RE: Moonview Short Plat (SP-08-00051)

Kittitas County Community Development Services hereby grants **conditional preliminary approval** to the Moonview Short Plat (SP-08-00051), subject to the following conditions:

**MOONVIEW SHORT PLAT**  
**PART OF SECTION 36, T. 18 N., R. 17 E., W.M.**  
**KITTITAS COUNTY, WASHINGTON**

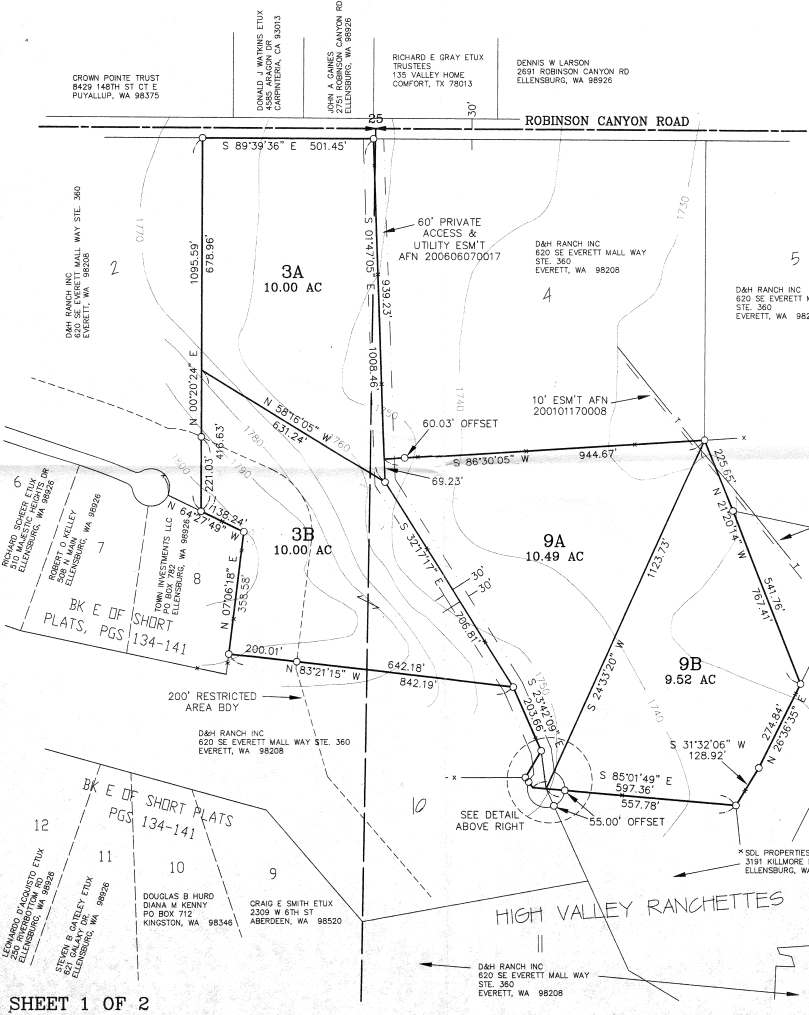
1. Both sheets of the final mylars shall reflect short plat number SP-08-00051 and an accurate legal description/map numbers shall be shown on the face of the final plat.
2. Full year's taxes must be paid on all tax parcel numbers pursuant to the requirements of the Kittitas County Treasurer.
3. One-time split provision. These properties have exhausted the use of the one-time split provision provided by KCC 17.31.040. No further division of this property will be allowed.
4. Replace plat note 8 with the following language:

The approval of this division of land includes no guarantee that there is a legal right to withdraw groundwater within the land division. The approval of this division of land provides no guarantee that use of water under the ground water exemption (RCW 90.44.050) for this plat or any portion thereof will not be subject to curtailment by the Department of Ecology or a court of law.

5. The remaining plat notes submitted on the preliminary drawings shall also be submitted on the final mylar drawings. Additionally, the following plat notes shall be added to the final mylar drawings:

- All development must comply with the International Fire Code (IFC) and its appendices.
 - Pursuant Kittitas County Code 17.31.040, this short plat has exhausted the use of the one-time split provision allowed per Kittitas County Code. No further one-time splits are allowed for the subject parcels and subsequent parcels created via this short plat.

- All lots of the Smithson Road Short Plat SP-08-00033 shall share a single ground water withdrawal of no more than 5,000 gallons per day. No more than ½ acre of lawn and garden shall be irrigated from this ground water withdrawal.

- Metering will be required on all residential well connections and metering results shall be recorded in a manner consistent with Kittitas County and Washington State Department of Ecology requirements.
